April 13, 1989

RE: REVISED DRAINAGE PLAN FOR OFFICE CONVERSION
911 FORRESTER, NW (J-14/D78) REVISION DATE OF MARCH 21, 1989

REVISED DRAINAGE PLAN

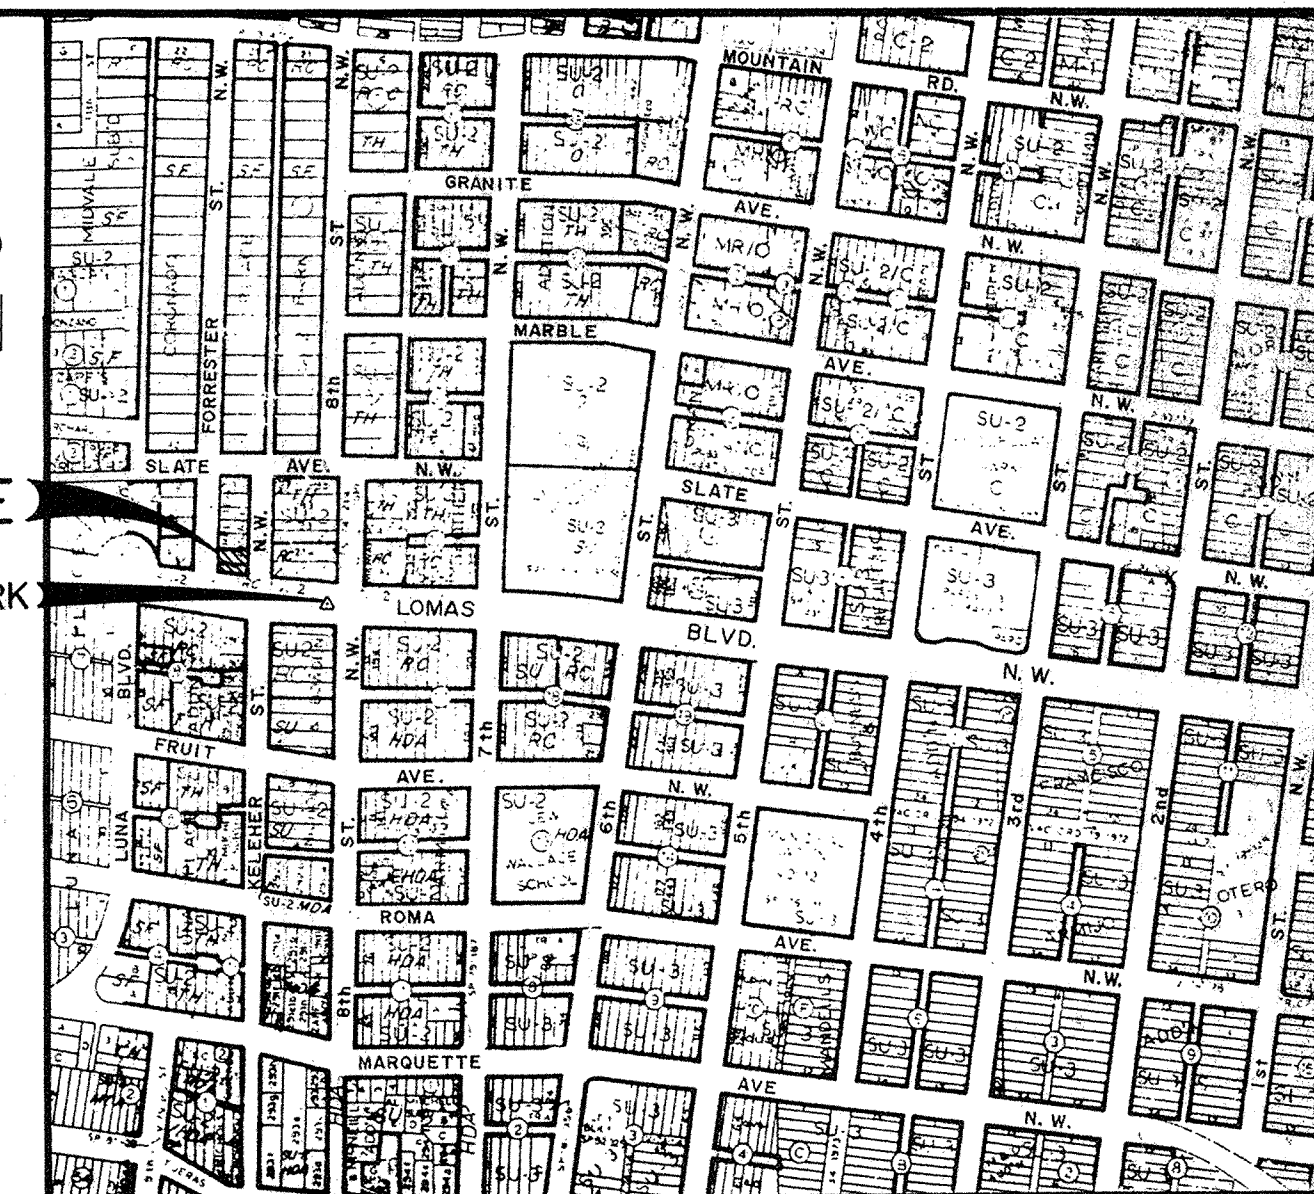
Based on the information provided on your resubmittal of March 21, 1989, revisions as indicated are acceptable. Please advise your client that all the developed runoff must exit the site through the existing drive pad.
